## **AUBURN CITY COUNCIL COMMENTS**

### **MIXED USE PROPOSAL FOR 1 BURROWAY RD WENTWORTH POINT SSD 6387**

Main waste Holding Room – Site Position

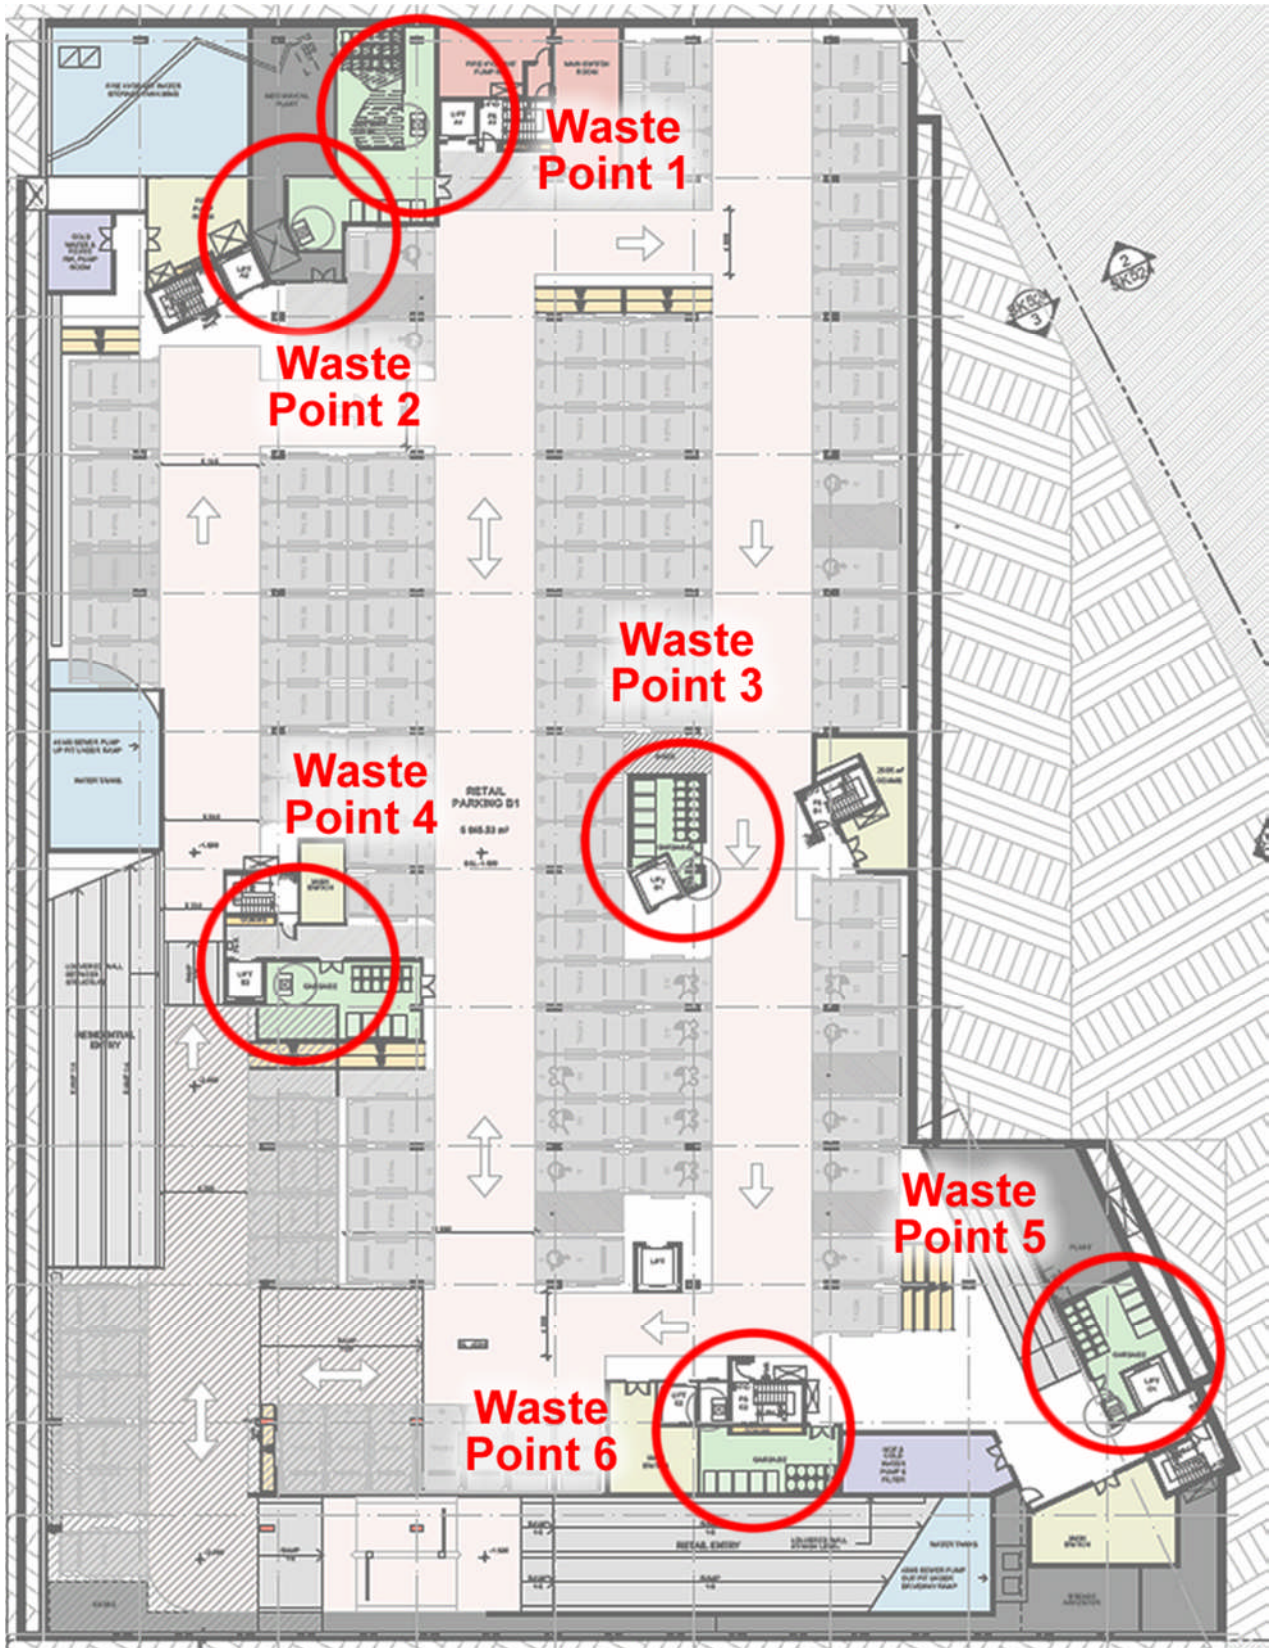
53. Council has concerns about the location of the main waste handling room so close to the vehicular access to the development. Council's position is not (as stated in the EIS) that waste collection is to be on road. Rather, Council seeks on-site waste collection.

SCALE: 1:200 @ A1
PROJECT NUMBER: 12005
DRAWING NUMBER: DA - 1002
ISSUE: 1

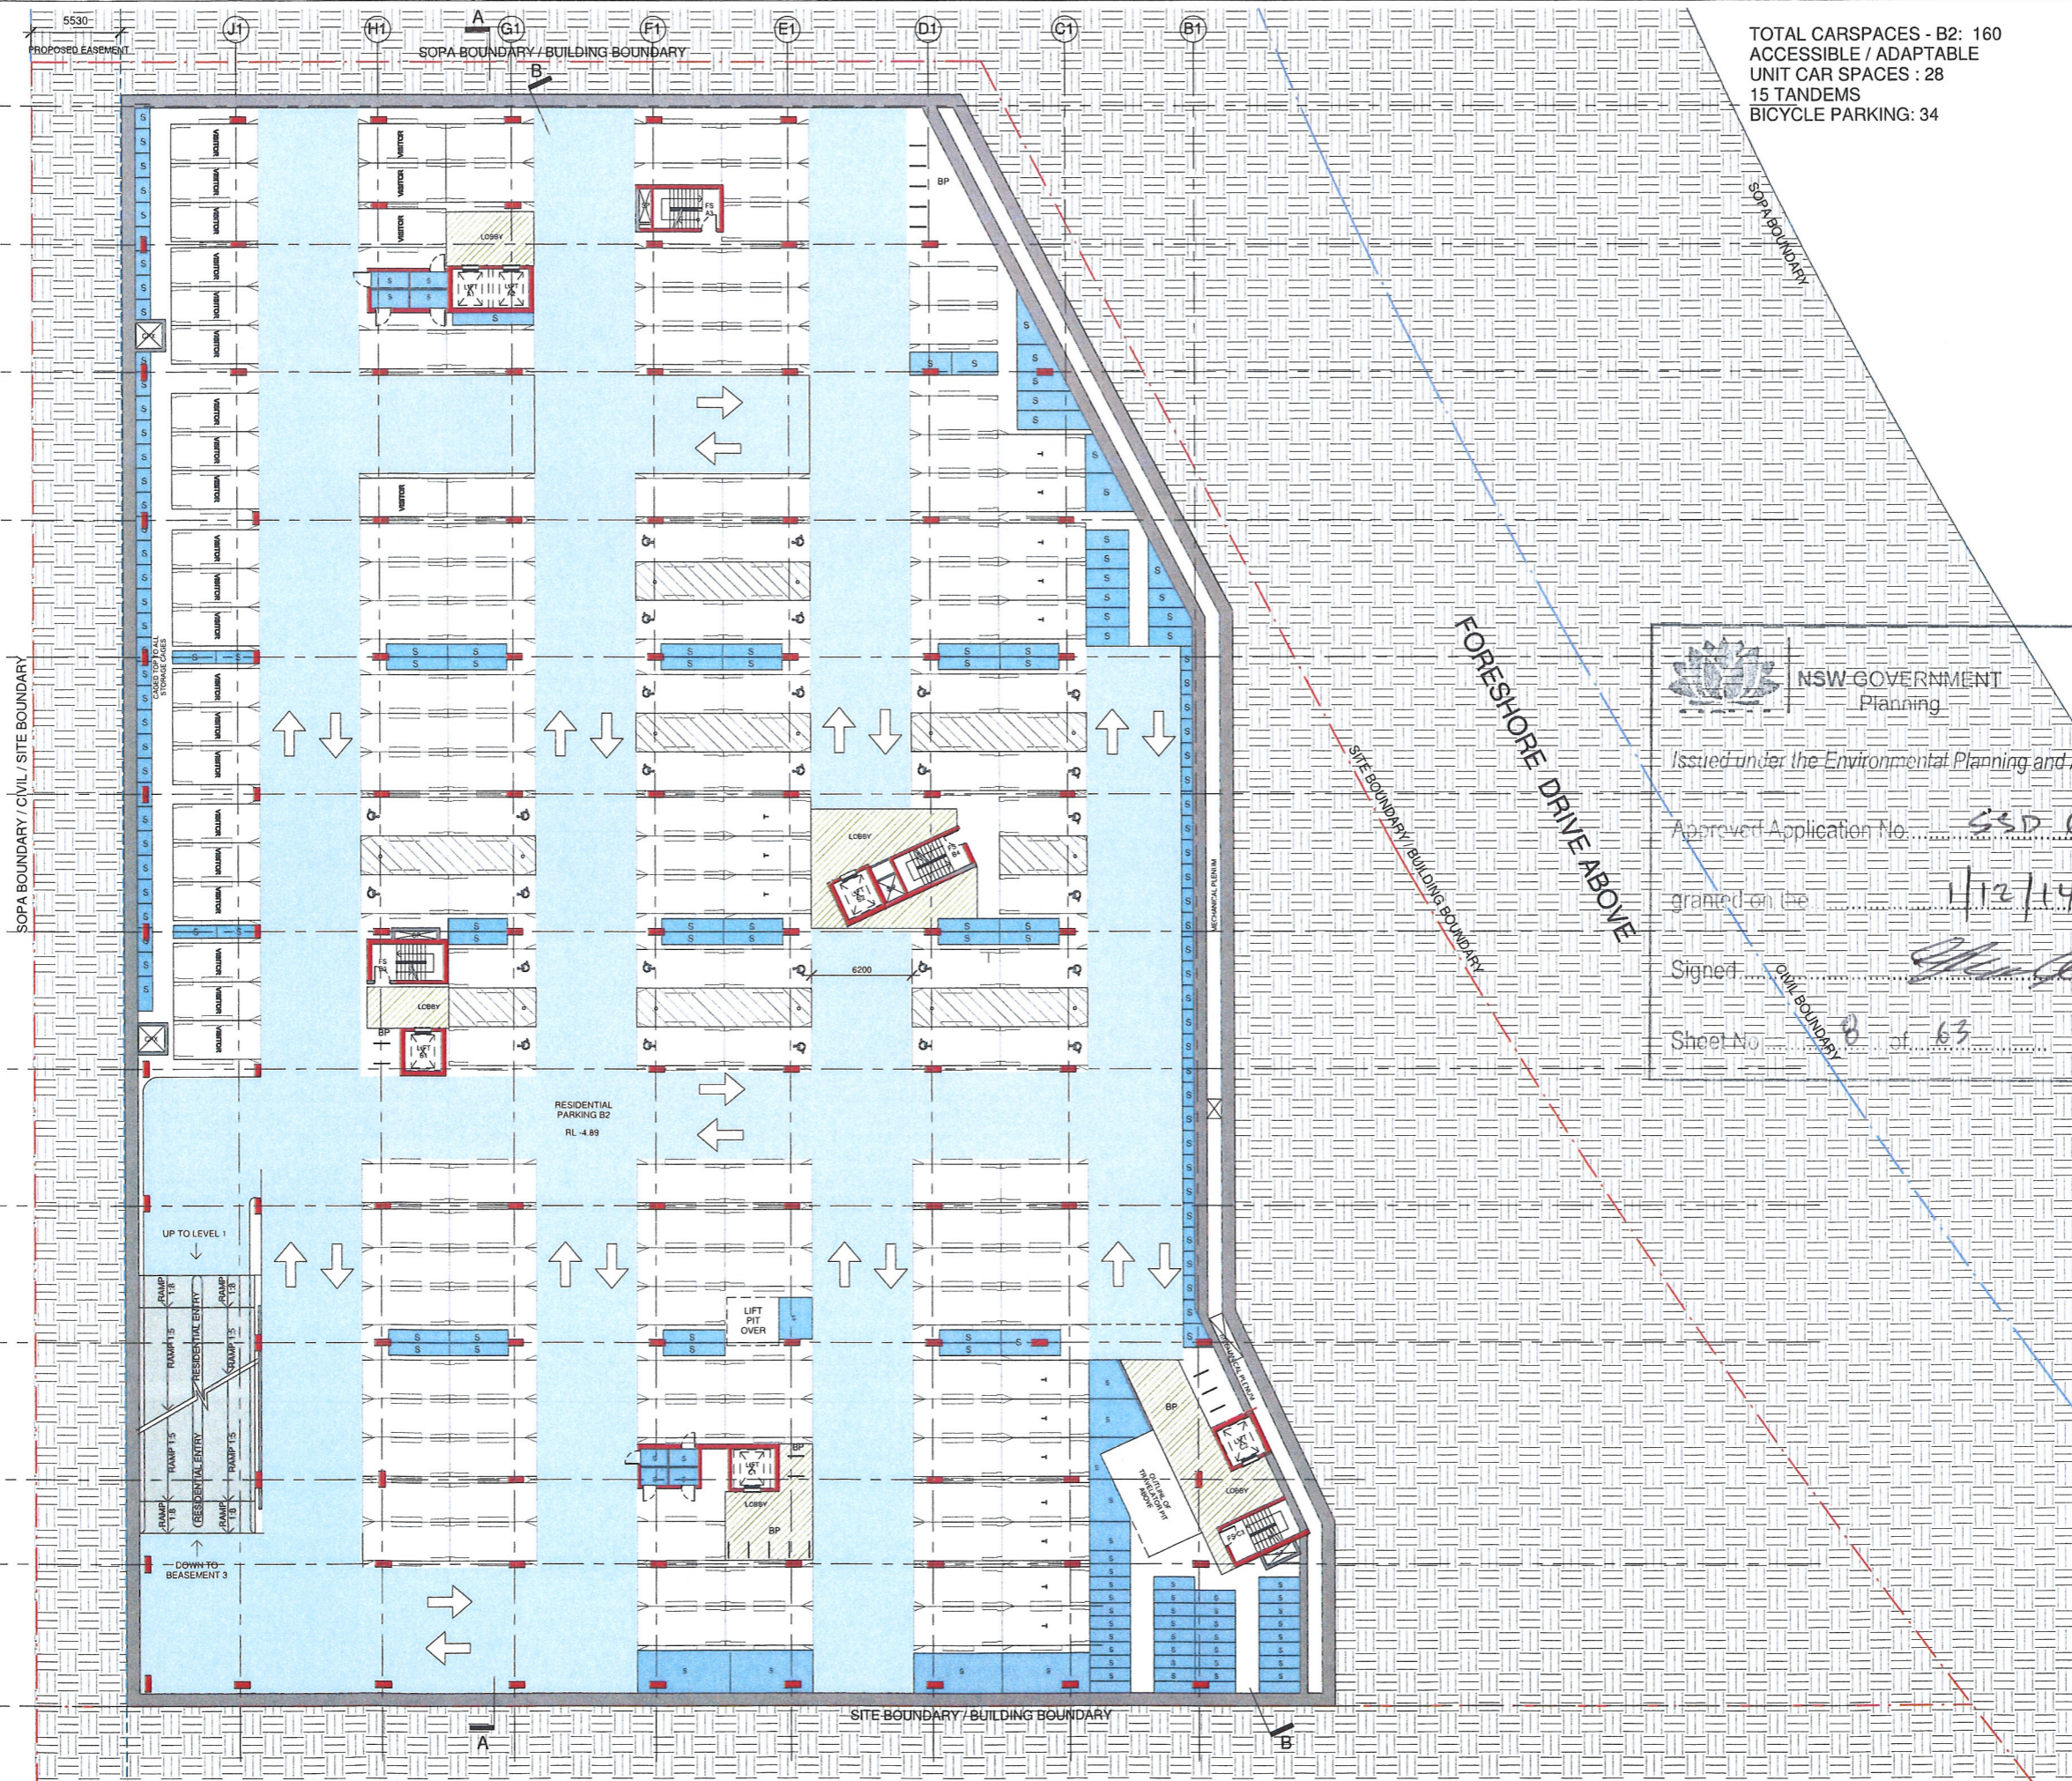
33. The submitted traffic report indicates that there will be two loading bays (HRV & MRV) for the retail area. The submitted plan does not indicate the two loading bays. Two loading bays should be shown on plan with appropriate turning circles to ensure that both can function independently.

34. In addition to the major retail, loading bay requirements for the other shops and child care facility have not been addressed.
35. The minimum head room requirement must comply with AS 2890.2.
